From: Melanie Jones [REDACTED]
Sent: 10 August 2015 14:34
To: Ross Leal
Subject: Update of land drain run at 31 Sea Way, Middleton on Sea M/56/15/HH

It appears that the plans for the land drain shown on the Planning website are incorrect regarding the application M/56/15/HH

Surface Water Drain
Sea Way
Middleton-on-Sea

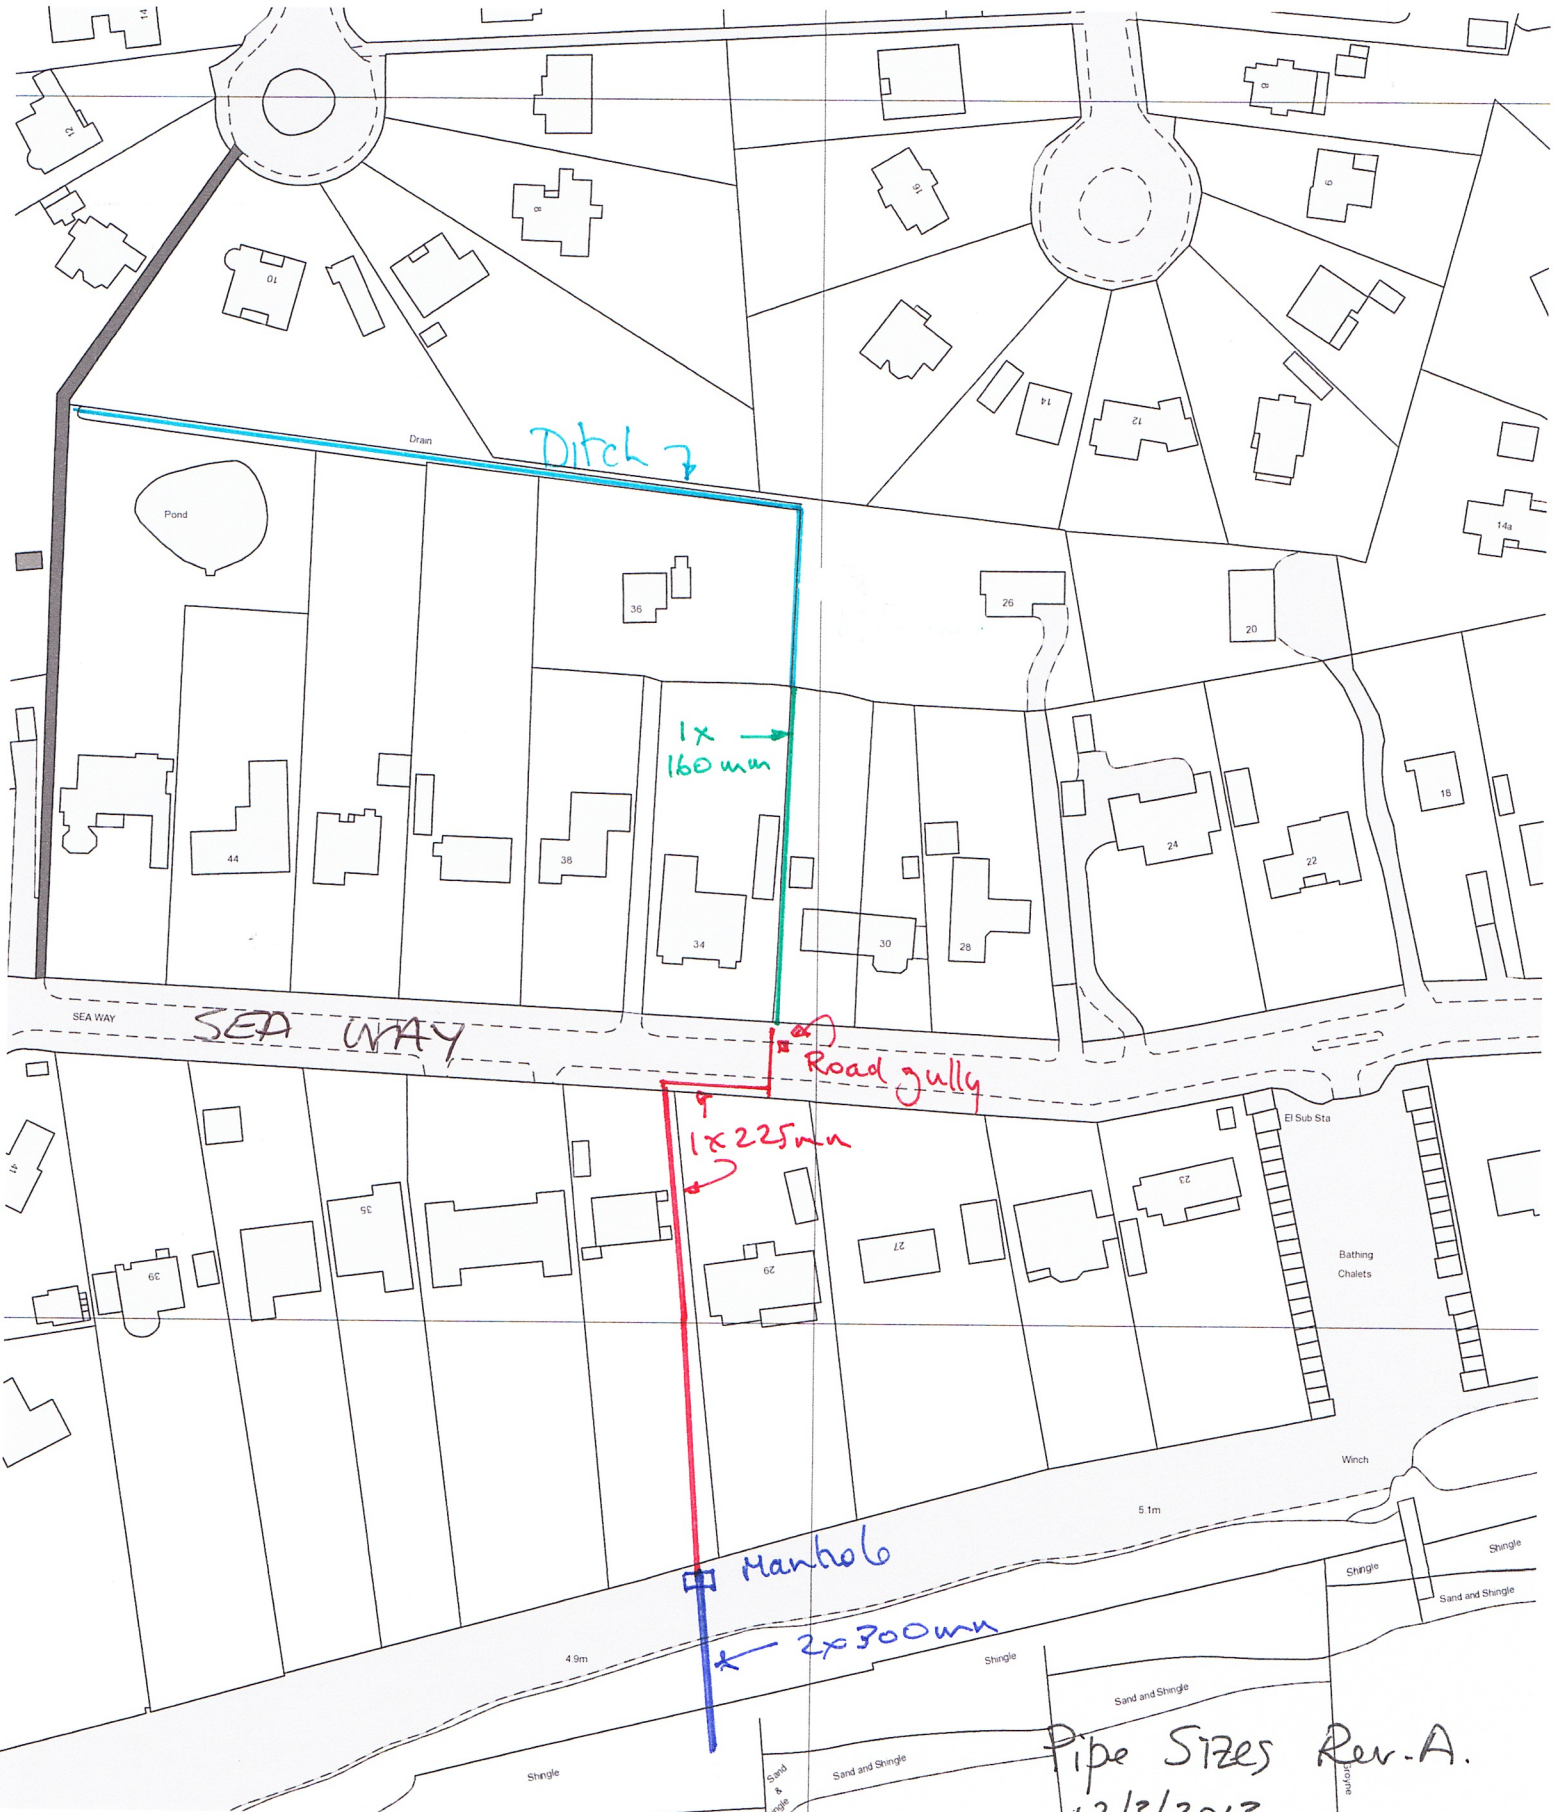
Please find attached the agreed estimate for the work and the accompanying plan showing the land drain run and pit numbers. Please note these are not to scale nor shows the position of the pits accurately. The original plan of

the land drain was used as a base showing the pits marked in type. The new pits as detailed in the estimate plan are hand written. The work was paid for by the house owner a large part of which was reimbursed, as agreed, by the Middleton on Sea Association as part of the full drainage works connected with this issue, once the works were agreed and finished.

The drain size is 225mm internal diameter twin wall (plastic) pipe encased in shingle not concrete.
